Holly English
6251 Cove Rd.
Ellensburg, WA 98926

June 22, 2008

RE: B & J Preliminary Plat (LP-08-21)

B & J PLAT
PART OF SECTION 7, T. 17 N., R. 18 E., W.M.
KITTITAS COUNTY, WASHINGTON
- PRELIMINARY PLAT -

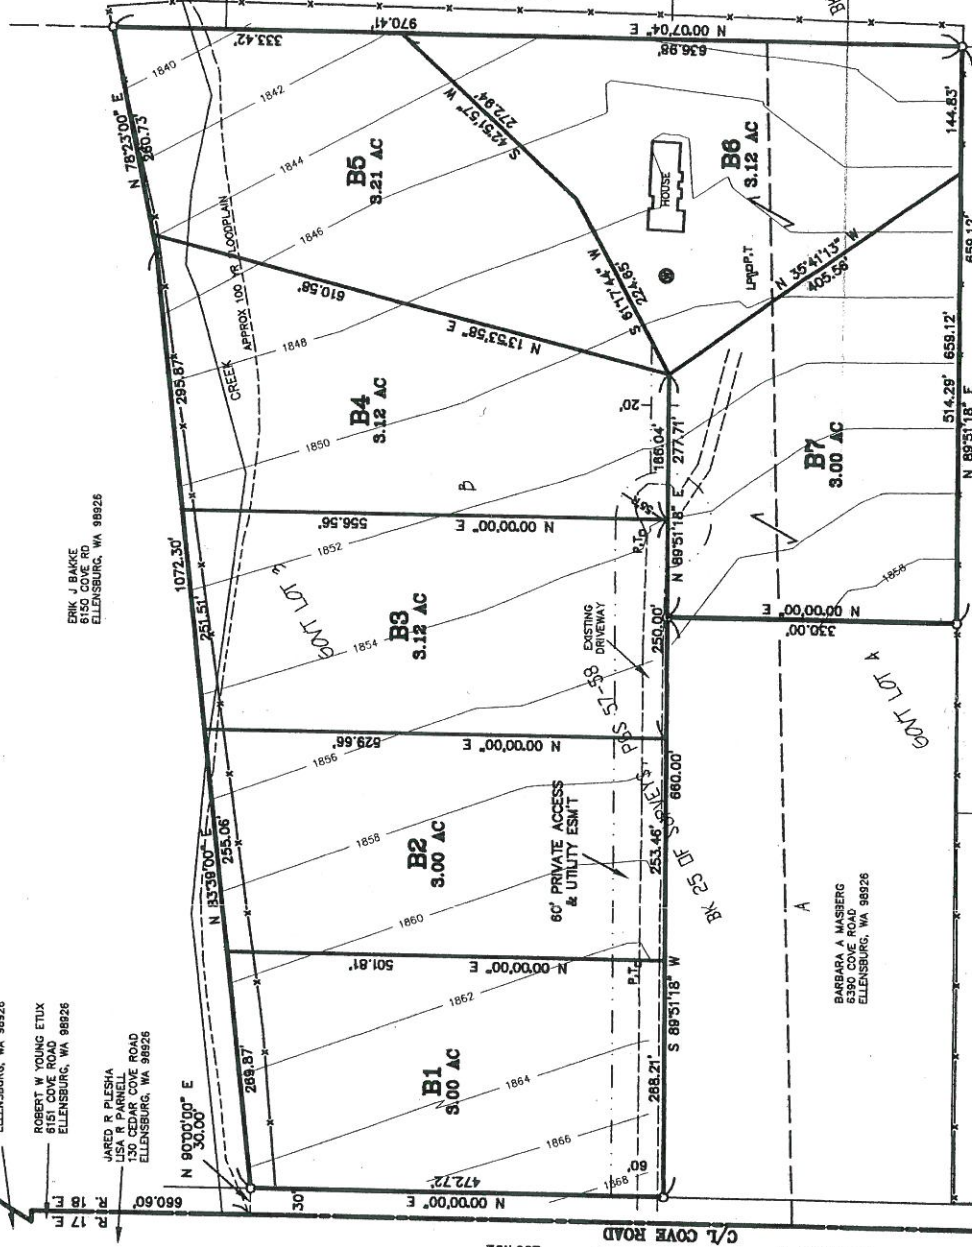
2. Wells: per the Campbell –Gwinn case, the entire project should fall under 1 exemption.
3. Reduce the overall density to 1 irrigable six-acre lot and 3 5-acre lots and require a group well.

4. The applicant should be required to have no-disturbance zones in the floodplain and riparian areas of Manastash Creek and a 25-foot setback from the DOE surface water. The applicant should be required to reseed and plant vegetation to prevent erosion along the driveway into the DOE surface water to maintain water quality.

Based on the following impacts, the County should recommend a determination of significance, and require the applicant to provide more detailed information on how the impacts will be eliminated or reduced. A preferred density strategy would be 1 six-acre lot consolidating the six irrigable acres, and three 5-acre lots, with protective buffers for the Manastash Creek riparian corridor and the ephemeral stream.
